Doc Ref: WE691-06F01(rev4)- WE Memo

**RE: BANKSTOWN CITY CAMPUS, WSU
PEDESTRIAN WIND ENVIRONMENT STUDY MEMO**

This technical memo presents an assessment of the updated design for the Bankstown City Campus development of the Western Sydney University (WSU) located at 74 Rickard Road, Bankstown.

DRAWING TITLE  
**PLAN - GROUND LEVEL**

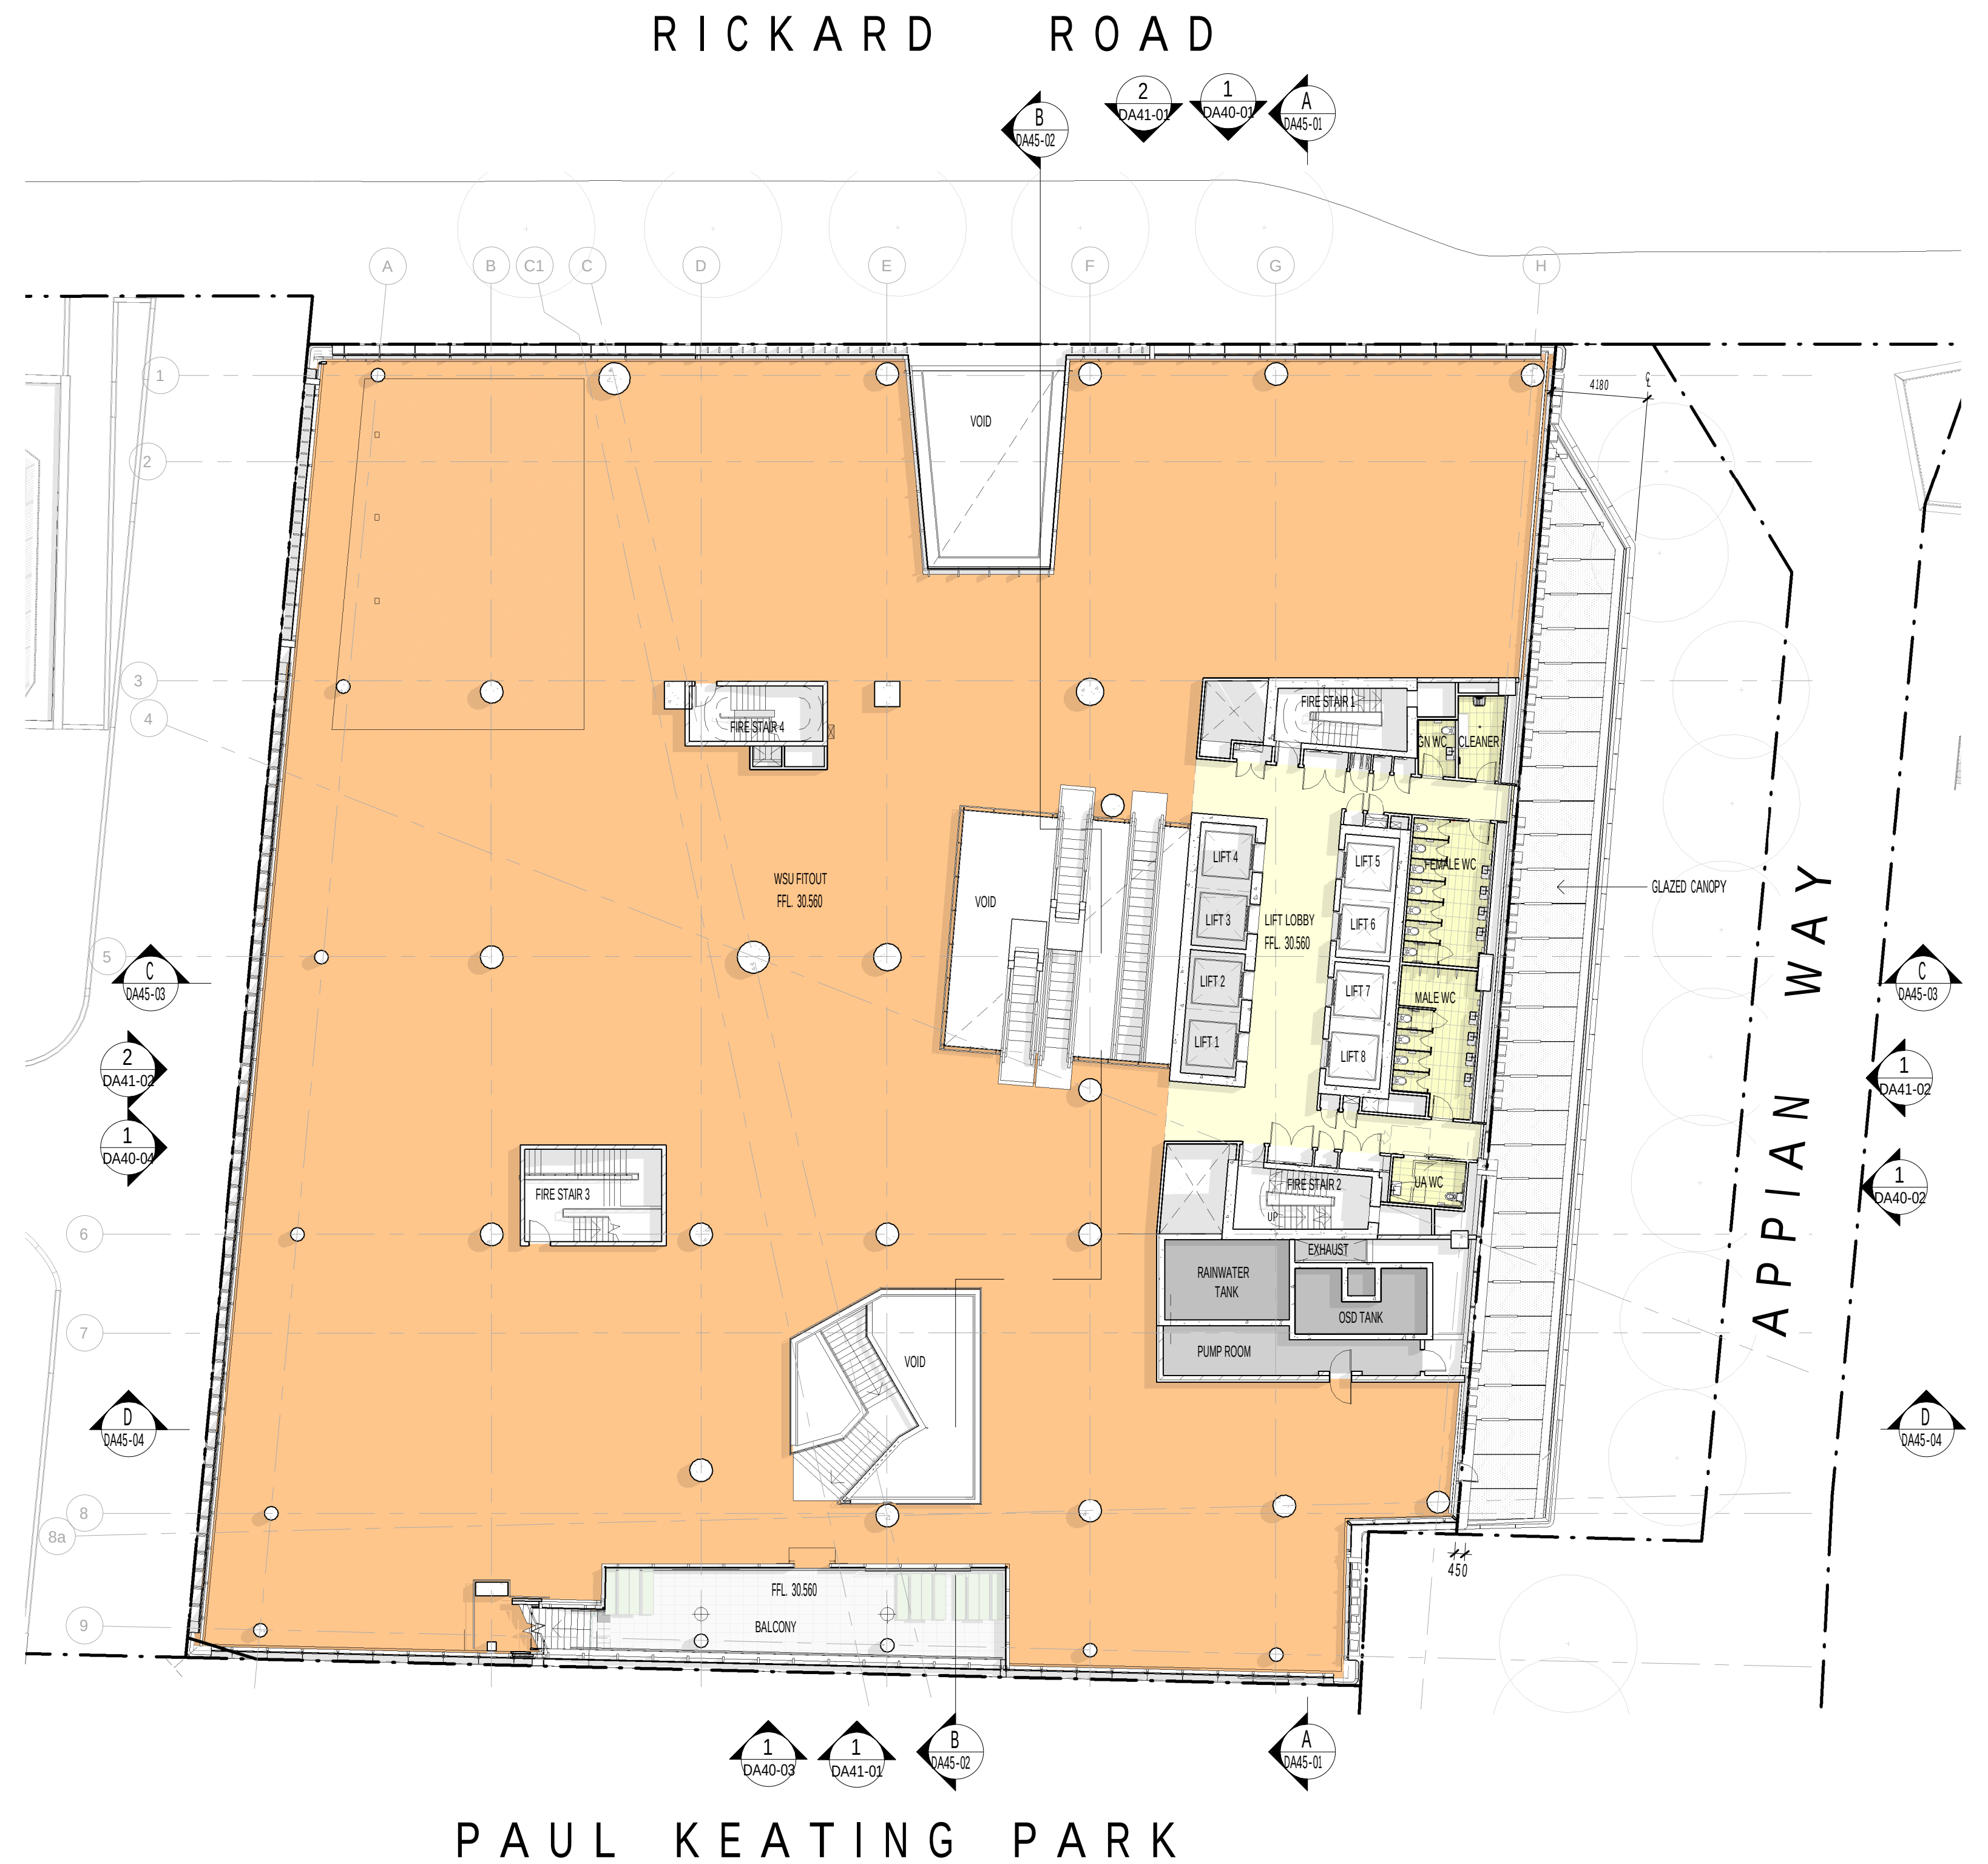
- Retain proposed densely foliating, evergreen trees along Appian Way and Paul Keating Park, as shown in Figure 1a. The selected trees (spotted gum) along Appian Way are suitable to offset the wind impact.

- Retention of the proposed cluster of densely foliating, evergreen shrubs at the south-western building corner on the Ground Level, as shown in Figure 1a.

- Retention of 3m high screens (impermeable or up to 20-30% porosity) near the south-eastern corner entrance on the Ground Level, as shown in Figure 1a.

- Retention of proposed revolving door at the northern entrance on the Ground Level, as shown in Figure 1a.
- Retention of proposed planters and undergrowth near the south-eastern entry on the Ground Level, as shown in Figure 1a.

- Retention of impermeable balustrade along the northern Juliet Balcony area, as shown in Figure 1a.
- Retention of a 1.6m high, impermeable balustrade along the perimeter of the balcony located on Level 02, as shown in Figure 1b.

DRAWING TITLE  
**PLAN - LEVEL 11**

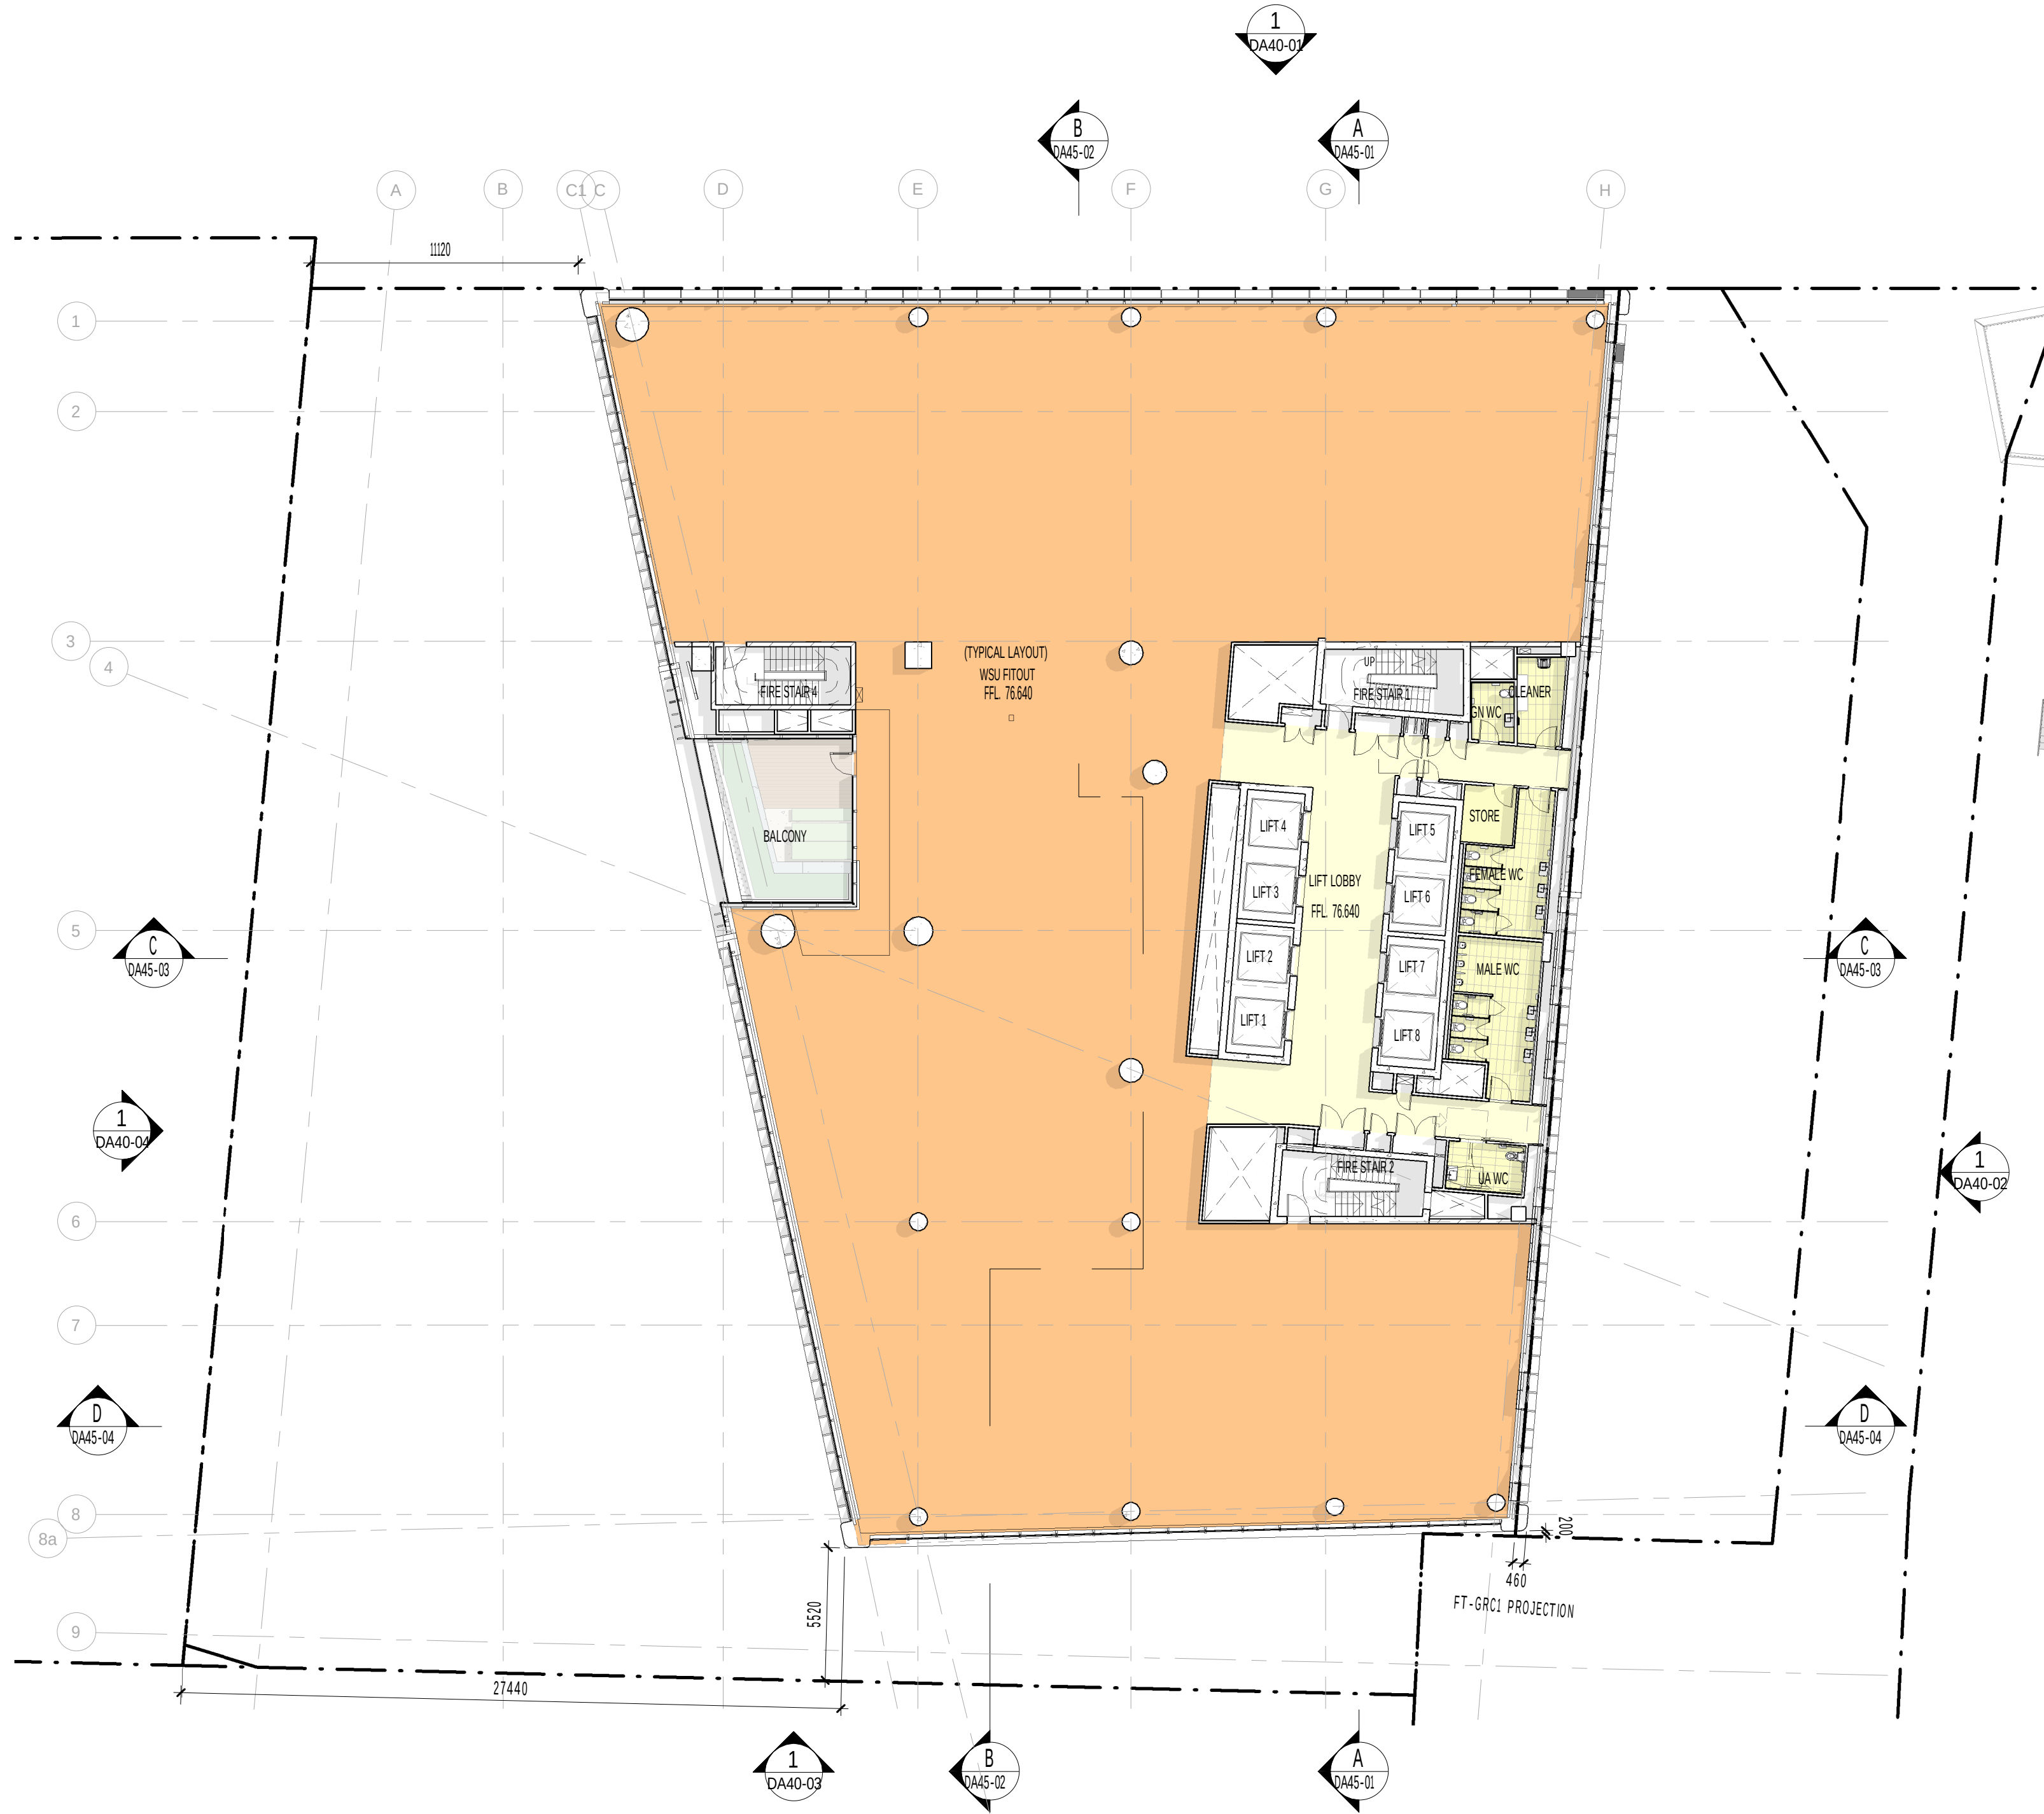
- Retention of an impermeable, full height screen along the northern perimeter of the north-eastern corner terrace located on Level 11, as shown in Figure 1d.

PROJECT  
**BANKSTOWN CITY CAMPUS DEVELOPMENT**  
74 RICKARD RD.  
BANKSTOWN NSW 2200  
DRAWING TITLE  
**PLAN - LEVEL 18**

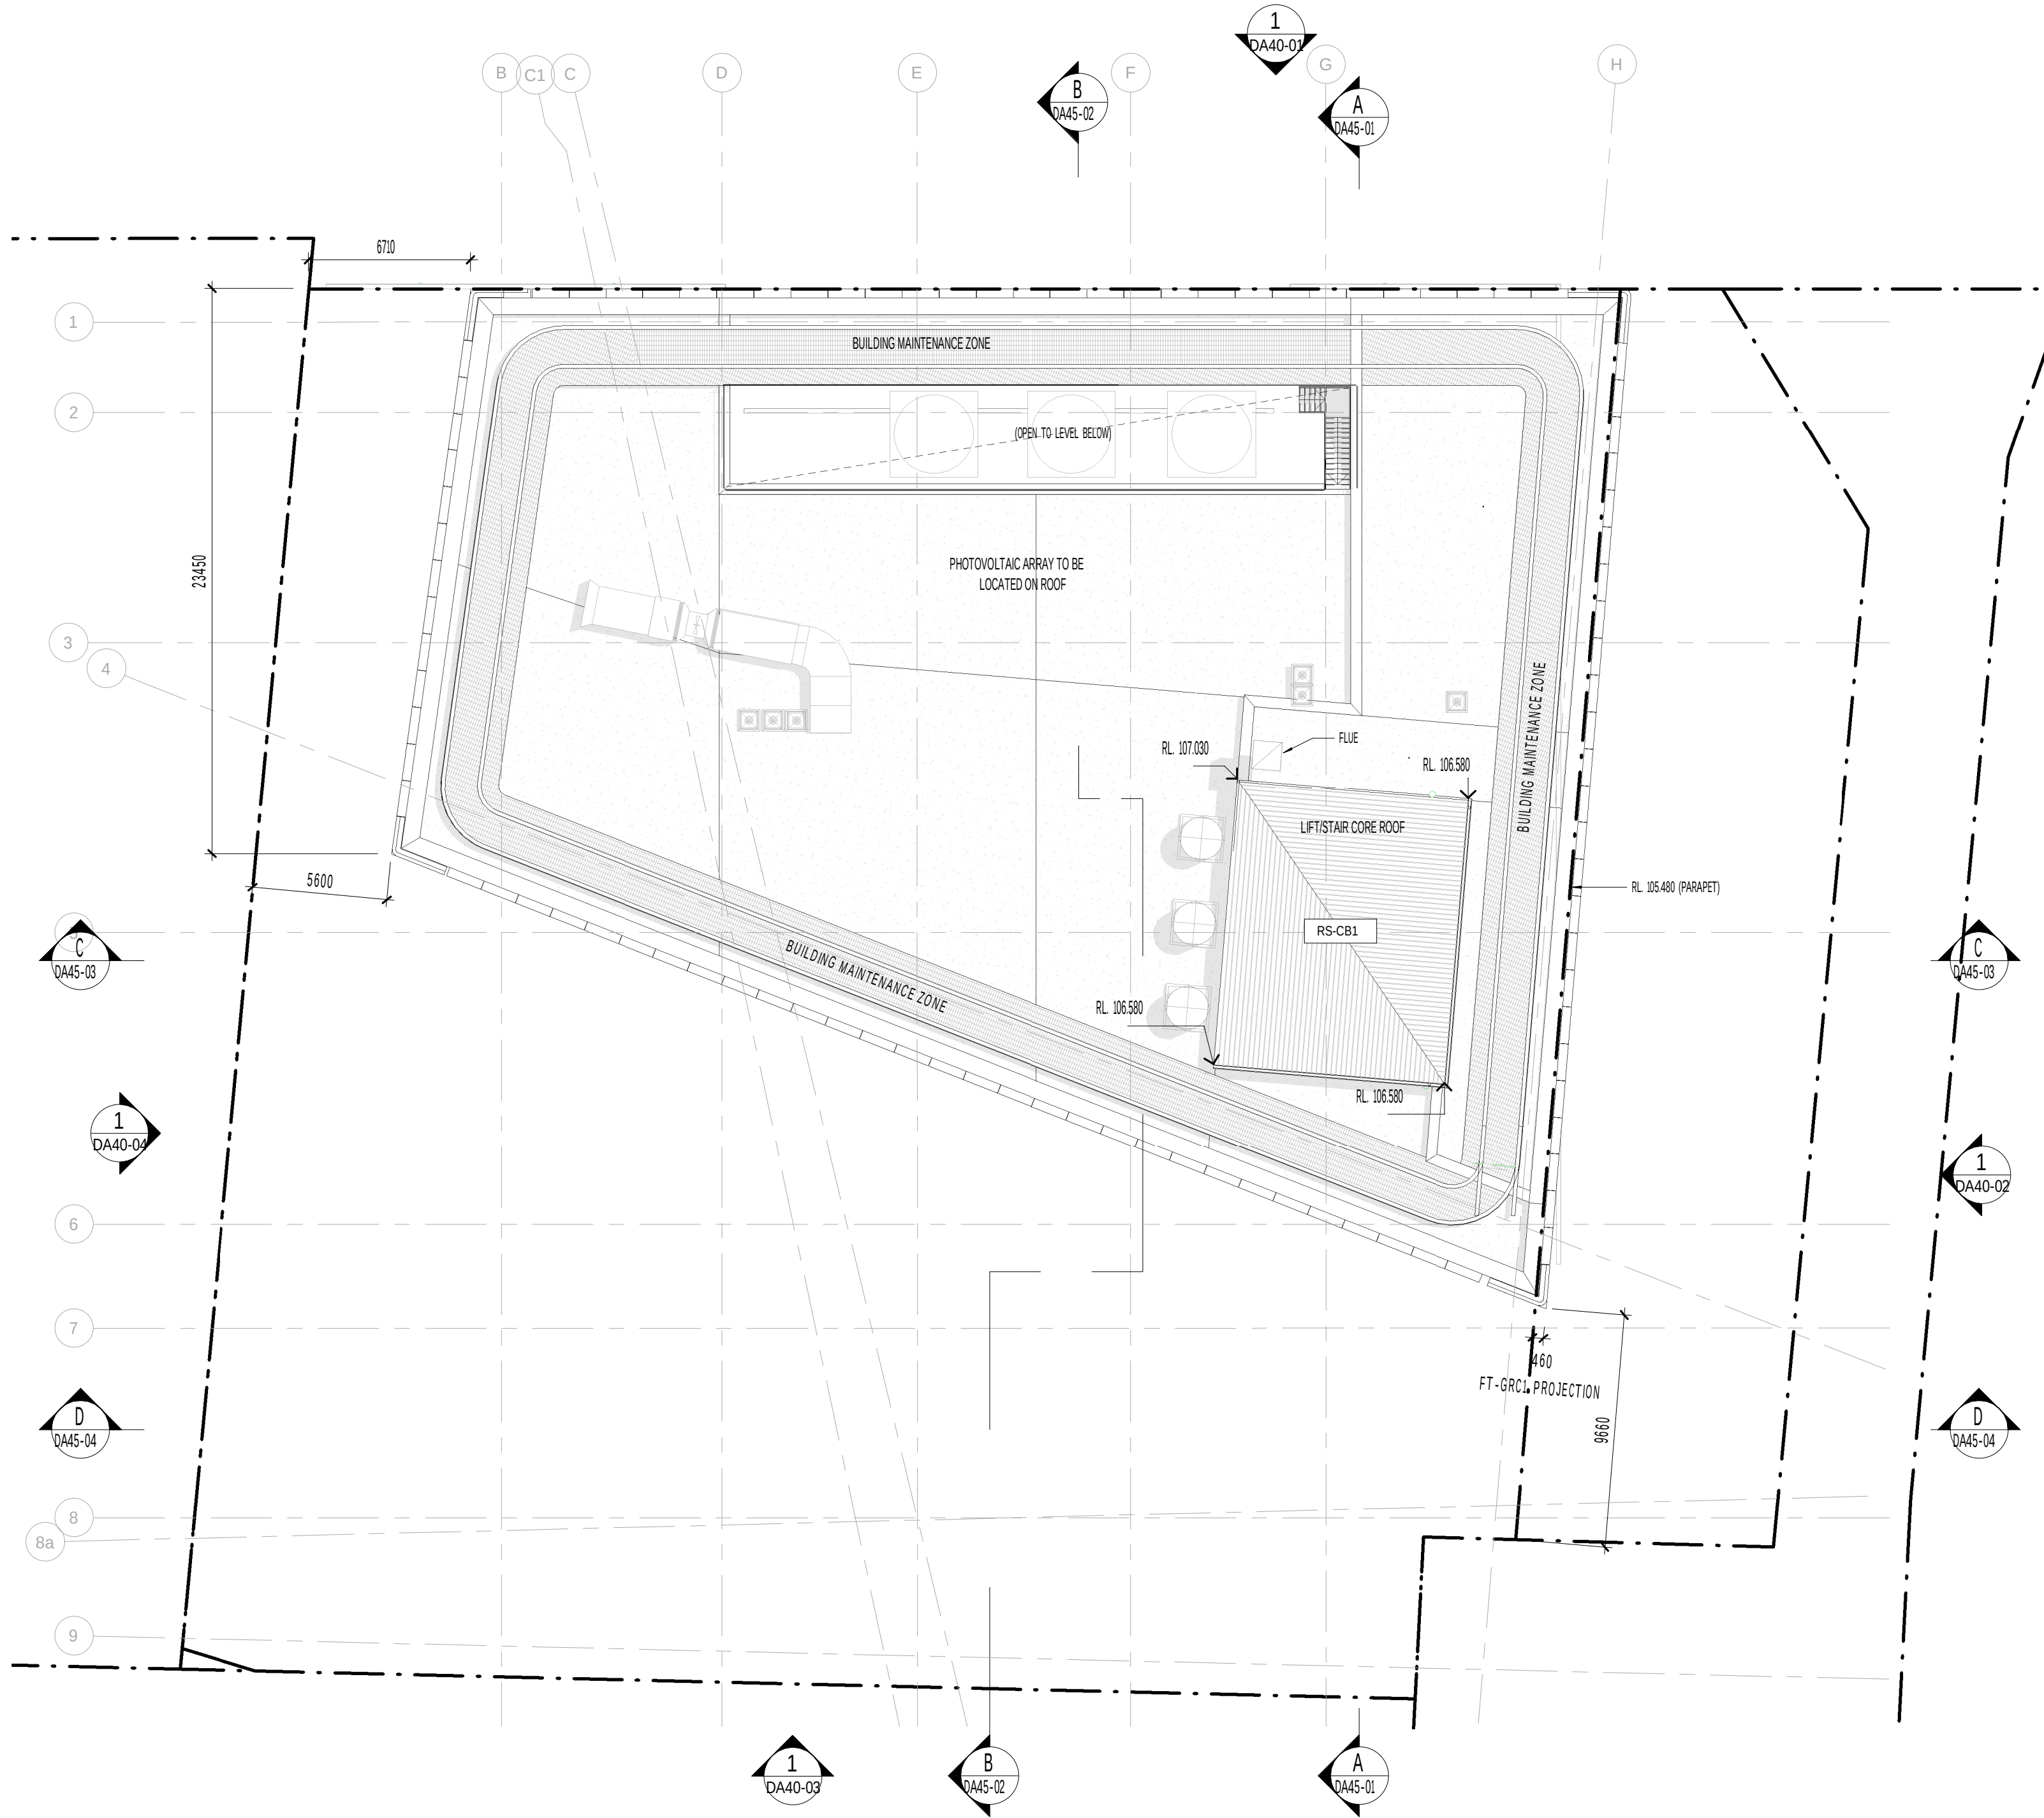
- Retention of a 1.2m high impermeable balustrade along the southern perimeter of the terrace located on Level 18, as shown in Figure 1g.
